ENTECH
ENGINEERING, INC.

Re: Response to Review Comments
Retreat at TimberRidge Filing No. 4
El Paso, Colorado
Entech Job No. 231468

Colorado Geological Survey, date June 4, 2024. *Review Comments by the Colorado Geological Survey, Retreat at TimberRidge Filing No. 4 (AKA TimberRidge Estates).*

PCD FILE NO. SF1827

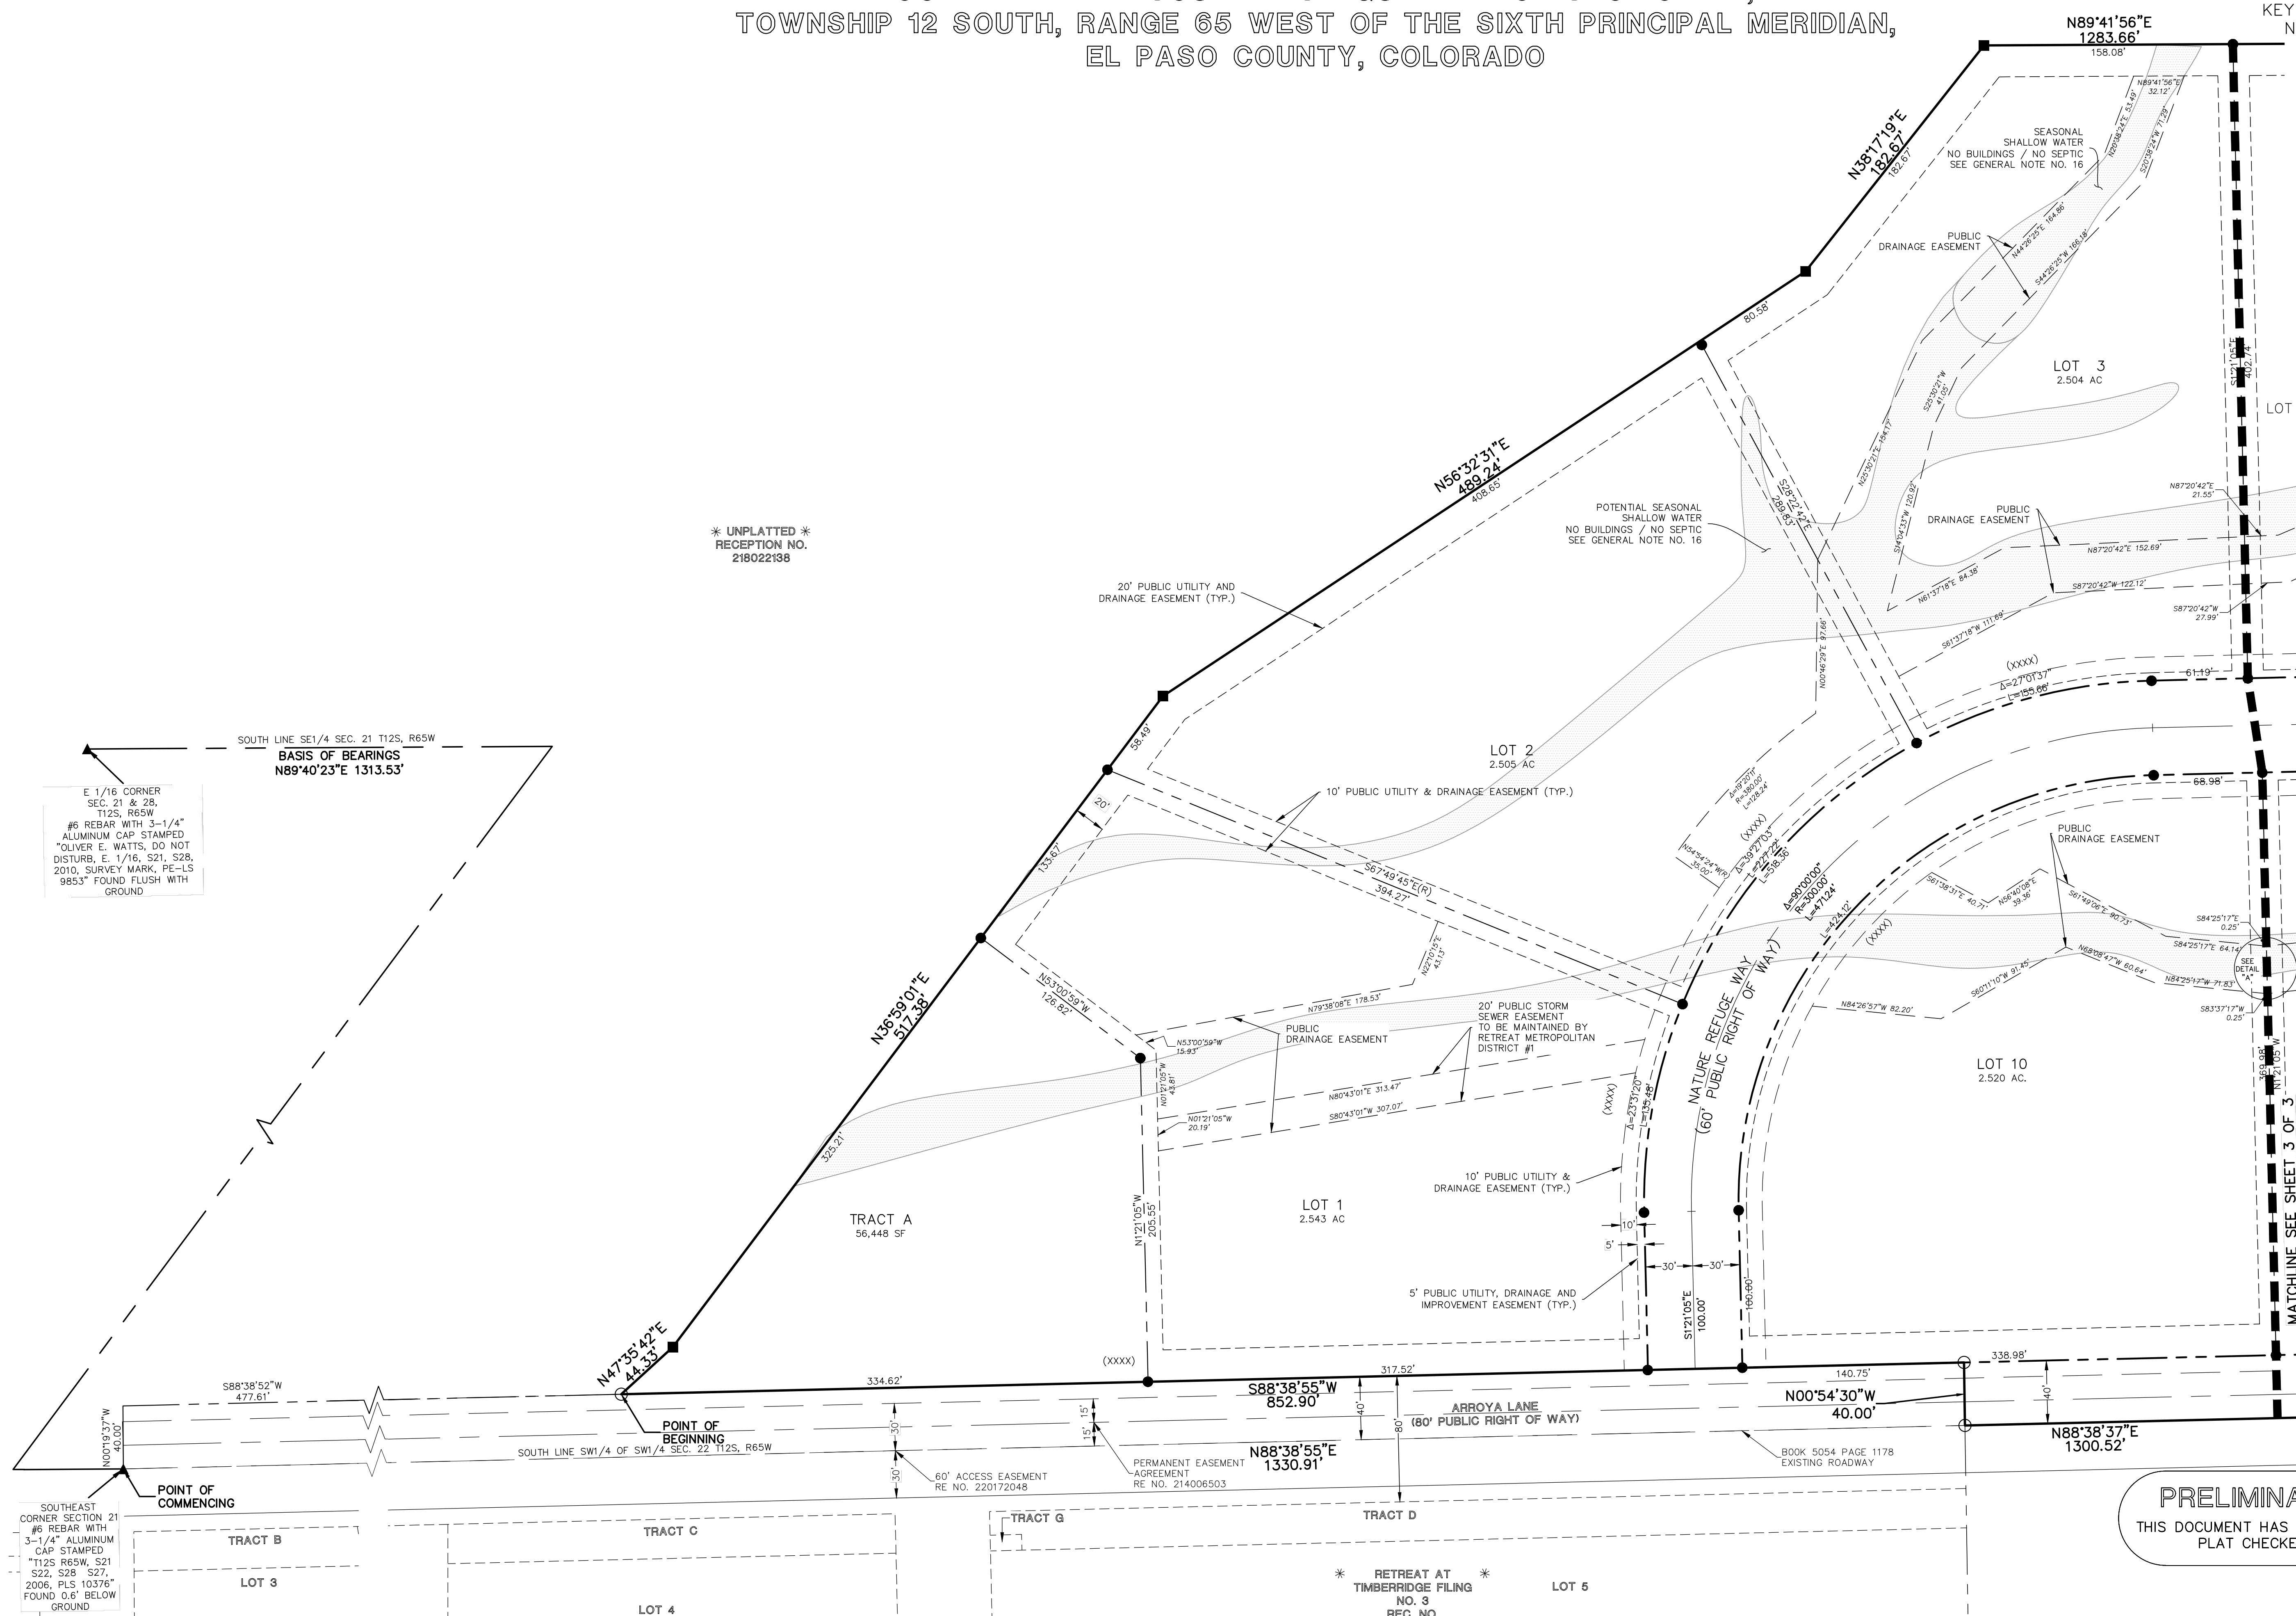
6/4/2024 10:46:40 AM 1. General note 16 of the final plat (Classic Consulting, February 22, 2024) indicates that geologic hazards and mitigation measures can be found in the Wastewater Study (Entech Engineering, Inc., December 21, 2023). However, mitigation measures for geologic constraints associated with Filing 4 were not included in this study. The final plat should be updated to reference the Soils and Geology Report.

Entech Response to Comment 1: General note 16 should reference the *Soils and Geology Study*, revised date June 14, 2024 for the geologic hazards and mitigation measures.
